**KIRKLEES METROPOLITAN COUNCIL
INVESTMENT & REGENERATION SERVICE**

DELEGATED DECISION TO DETERMINE PLANNING APPLICATIONS

Reference No: 2021/62/92983/W

Description: Erection of single storey rear extension and external alterations

DRAWING NUMBER: 1022 - 02 REVISION: B

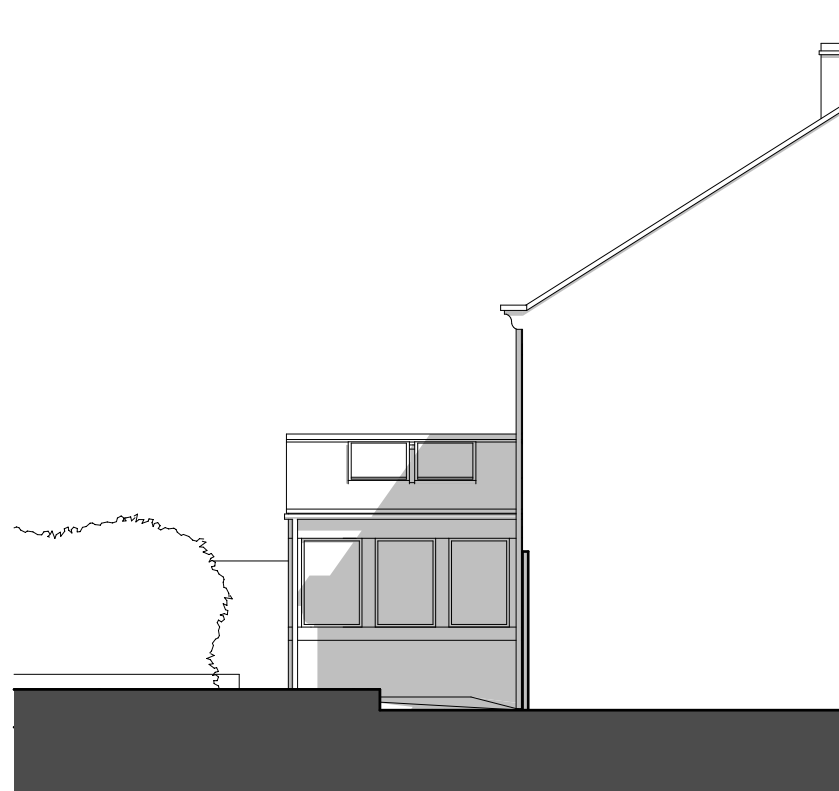
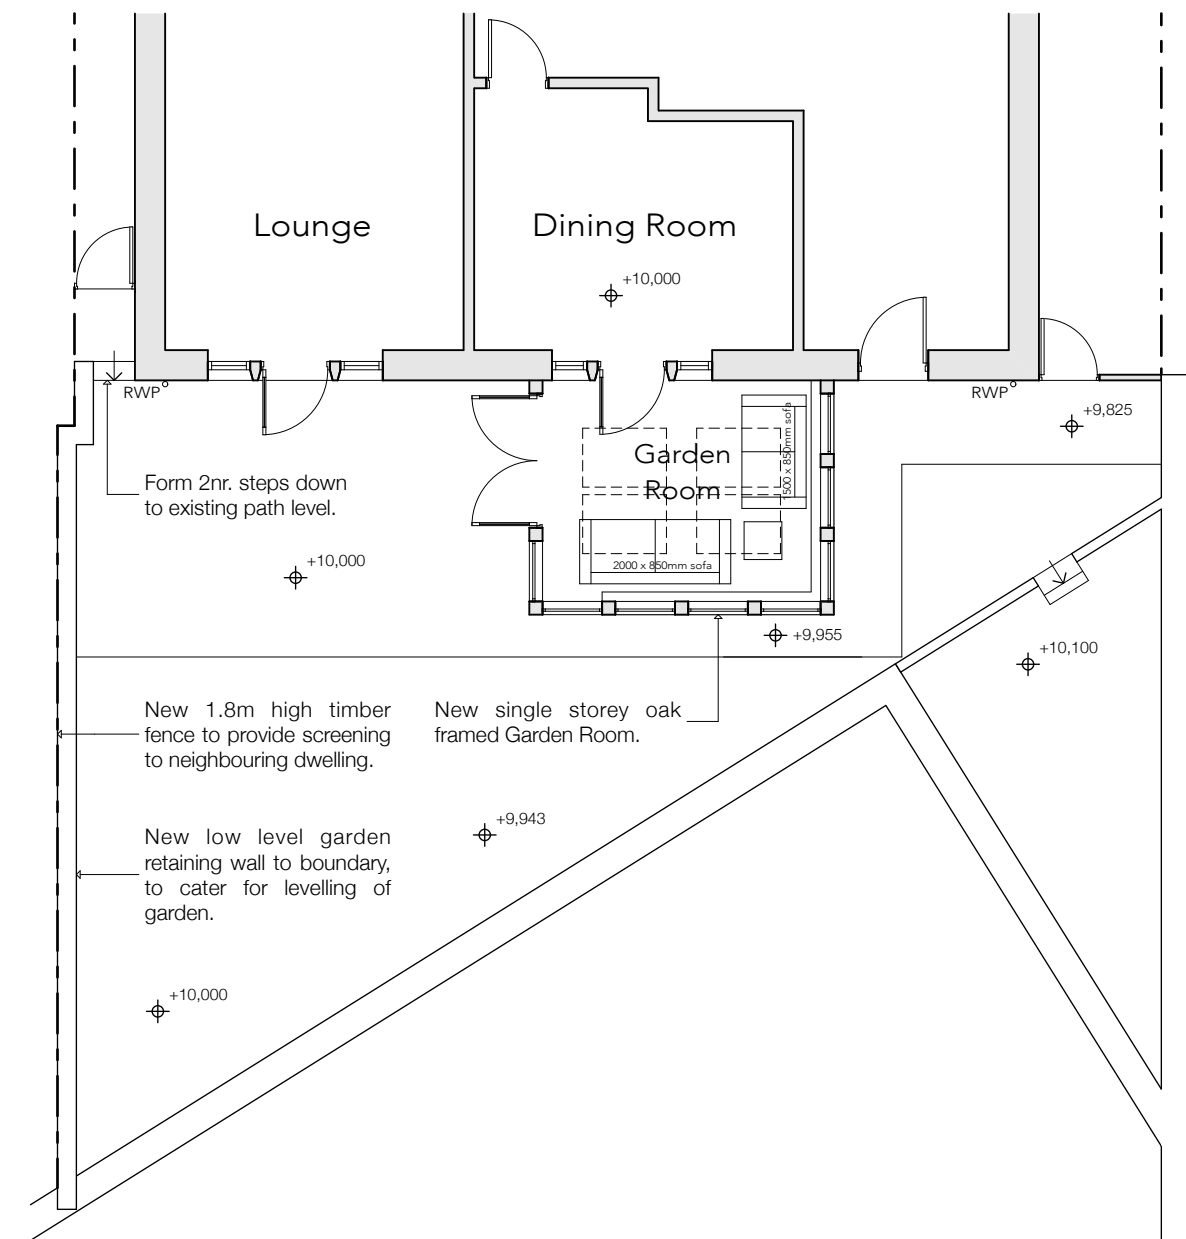
The proposed single storey extension would be located on the rear elevation of the property set in from the side elevation facing No. 22 by 5.2 metres and from the side elevation facing No. 26 by 2.7 metres. The extension itself would project a total of 3 metres from the rear elevation of the property and would be a total width of 4 metres with an eaves height of 2.5 metres and overall height of 3.7 metres to the ridge of the pitched roof. The proposed construction materials are natural stone and oak frames for the walls and artificial stone slates for the roof.

The proposed external alterations within the site would be new 1.8 metre high timber fence along the shared boundary with No. 22 and a new low level garden wall (0.4 metres in height) to retain the levelling of the garden.

Due to topography, the adjacent property No. 22 is set on a lower ground level than the application site and No. 26 is set on higher ground level. Existing and proposed site levels have been indicated on the submitted plans

and the proposed extension would be on the same ground level as the existing land. The extension is set in from both side elevations of the property and due to the existing screening in situ along with the proposed fence height, it is not considered that there would be material harm from overshadowing, overlooking or oppressiveness / overbearing impact.

In terms of the impact from the proposed boundary treatments it is proposed that the ground levels would be increased along the area close to the boundary with No. 22 and a 1.8 metre high fence installed. There would be an increase of between 0.4 metres and 0.5 metres to level off the garden. Given the fence above this would be limited to 1.8 metres it is not considered that the impact would be so significant to the neighbouring property in terms of being overbearing that there would be sufficient justification to refuse the application on this basis. In addition, the proposed fence would be located to the north-east of the application site and therefore it is not anticipated that there would be a significant loss of direct sunlight.

- Appears the extension will be on a higher ground level than the existing ground level and concerned about intrusion from windows and doors

- Concerned regarding construction and height of fence above the retaining wall

- Not in agreement to the boundary wall as the wall is already 0.7 metres and adding a further 1.8 metres would affect light and create a narrow passage which could be an issue for remedial maintenance

Response: This has been addressed within the residential amenity section of this report

Response: This has been addressed within the residential amenity section of this report

Response: The height of the fence and the impact on the neighbouring property has been addressed within this report. Access for maintenance is not a material planning consideration

DRAWING TITLE: Location Plan

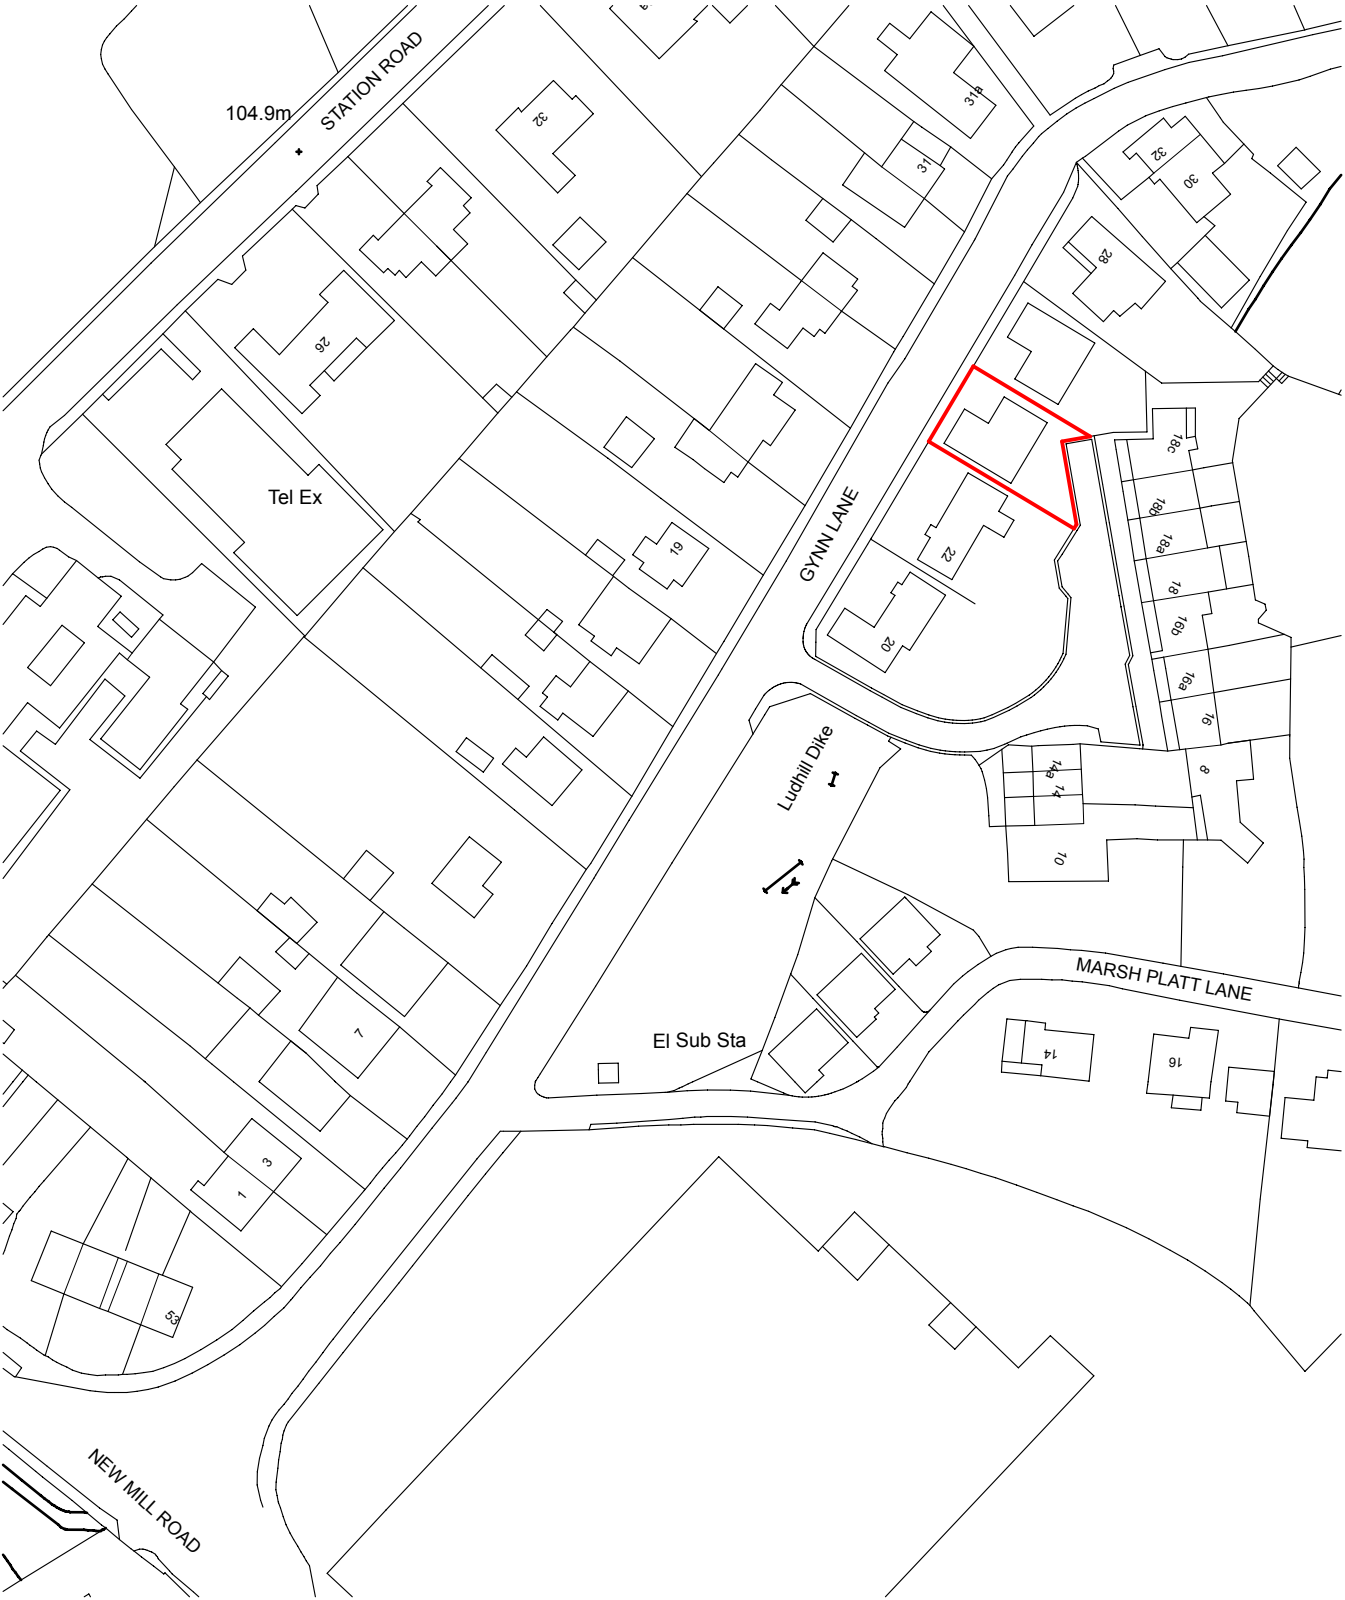
- Red line drawn on plan differs to that at the time of purchase

Response: The red line boundary of the site appears to be the same as the Land Registry records held on the Council's mapping system

DRAWING TITLE: Culvert Plan

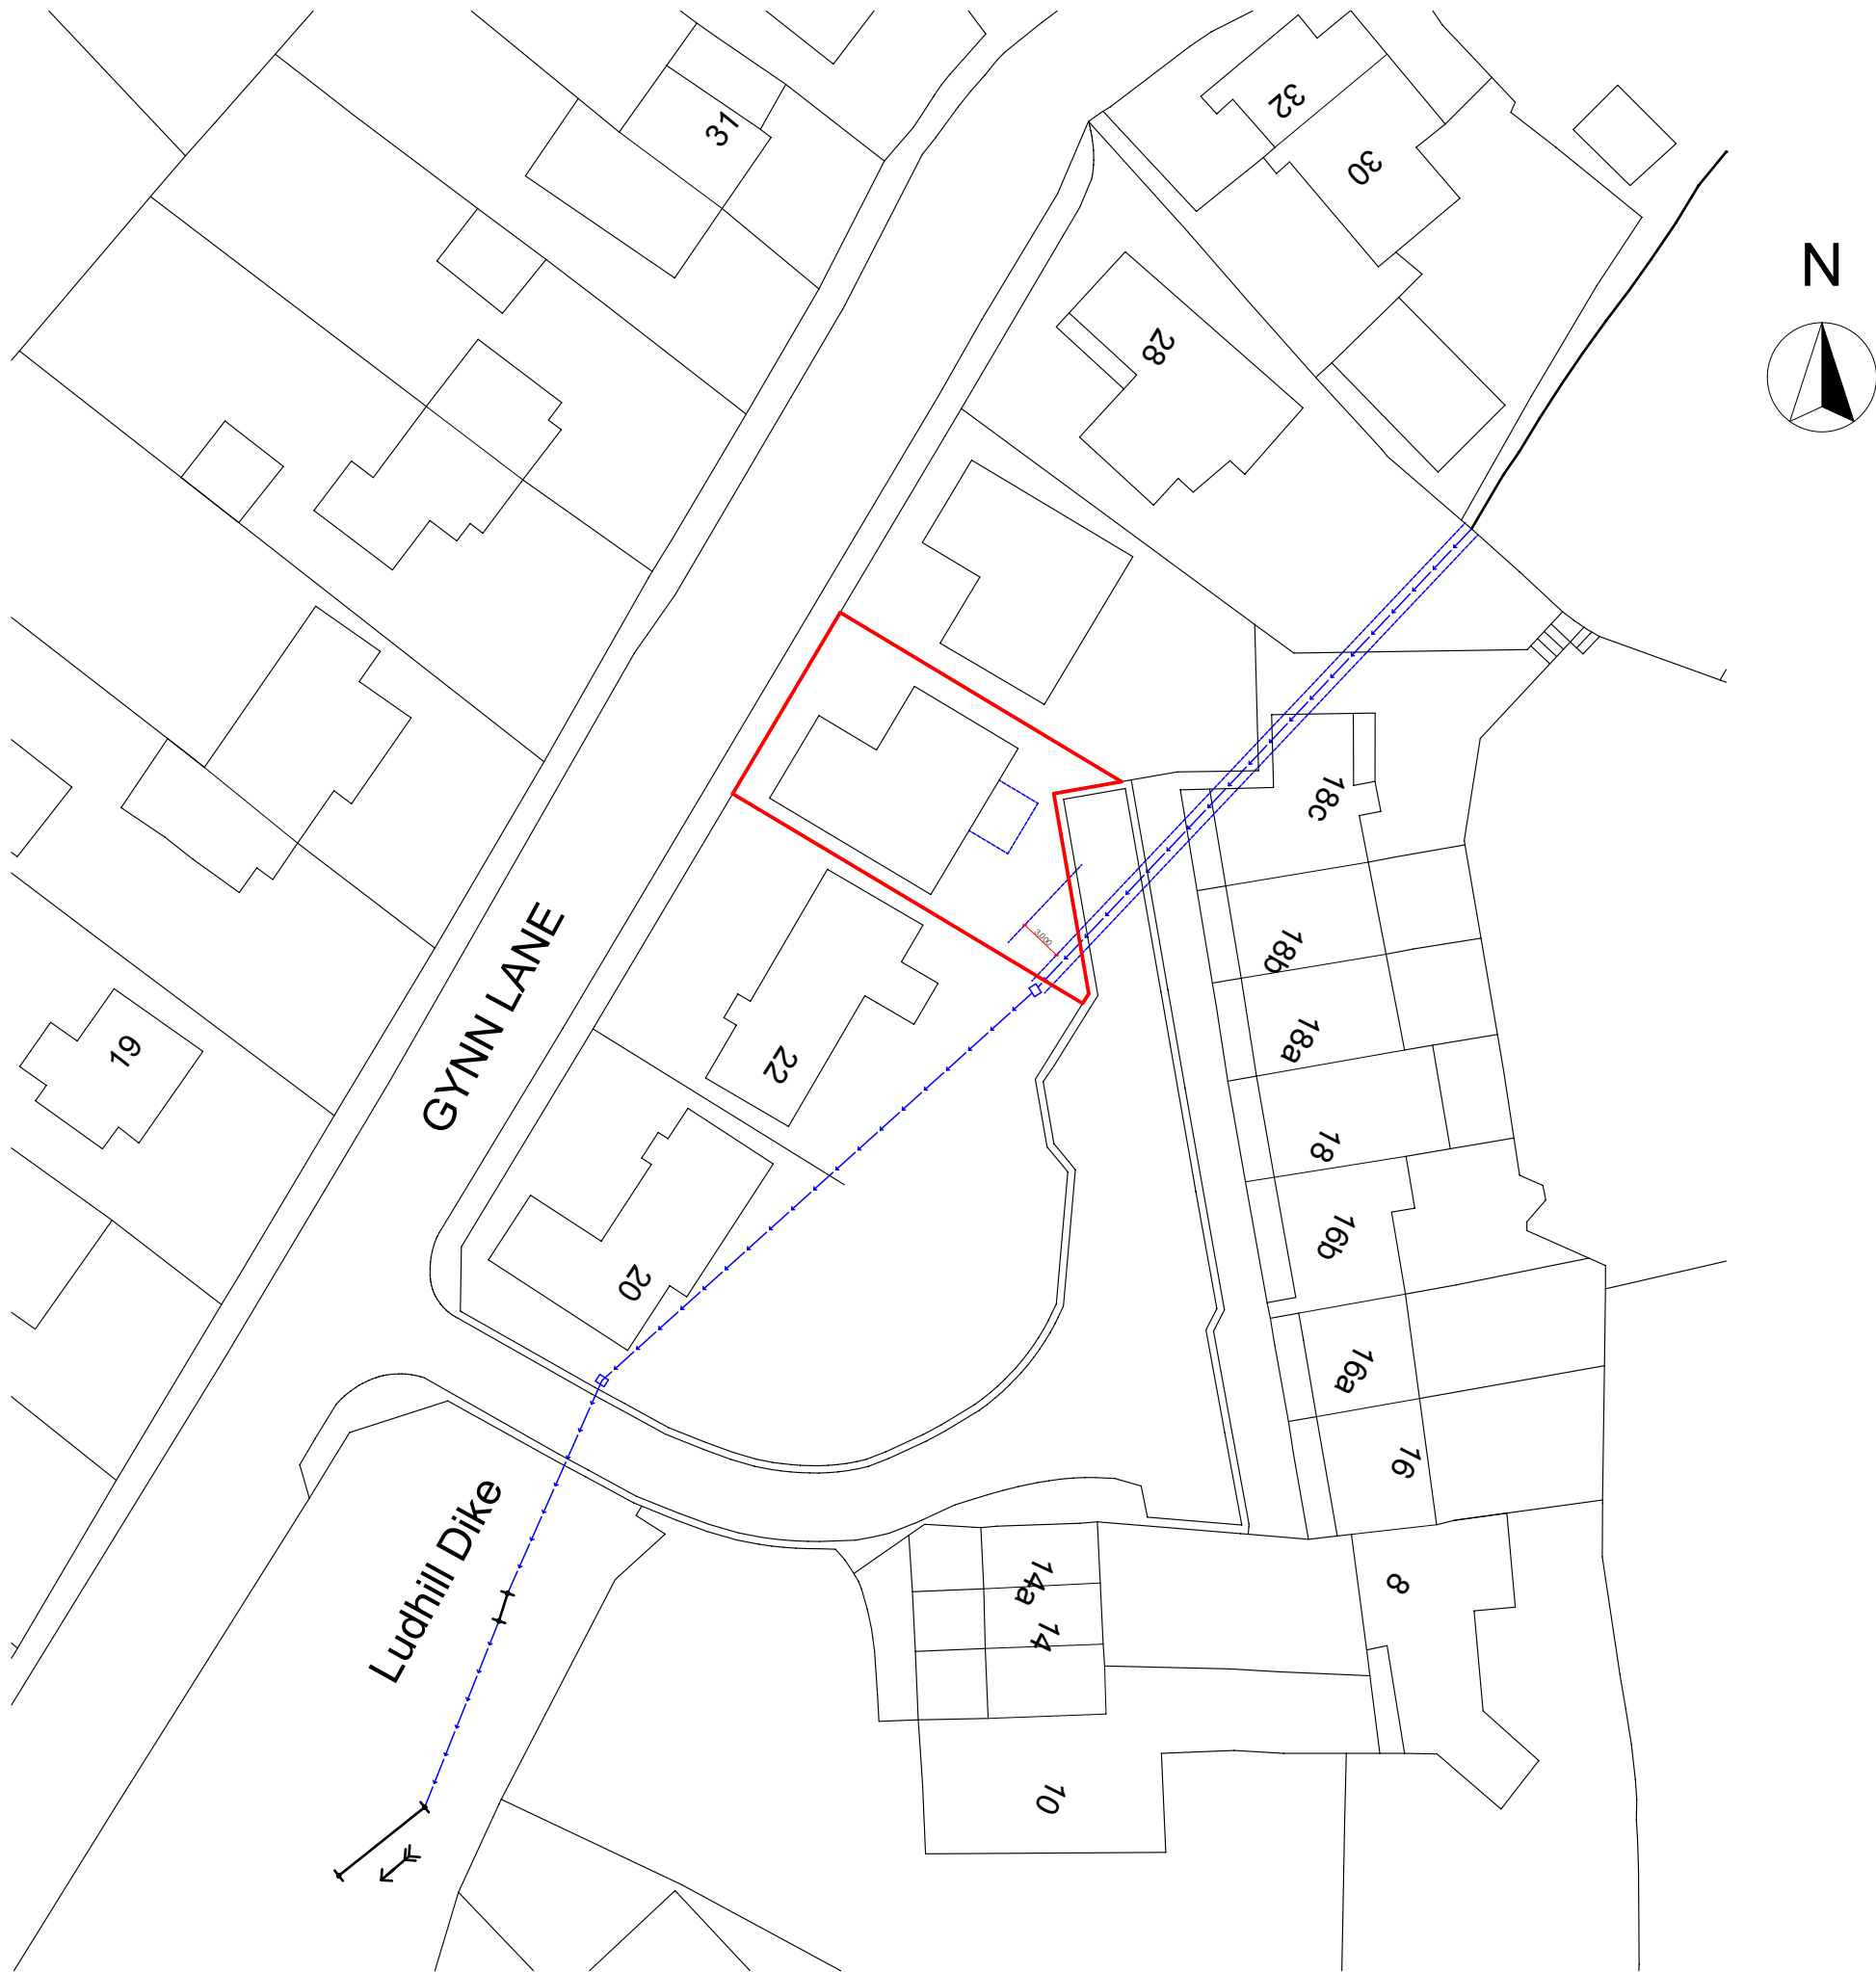
Drainage – the Council's mapping system indicates that there is a culvert running through the garden area of the application site. The LLFA were formally consulted and due to the proximity of the watercourse, objected to the proposal. Following on from information being submitted and also the LLFA obtaining CCTV survey, it is not considered that the works would suggest a dangerous encroachment. As such, the objection has been withdrawn and the proposals supported.

- Culvert runs through the top of the garden

Response: The Lead Local Flood Authority were formally consulted as part of the application process and whilst initial concerns were raised, the objection has since been withdrawn
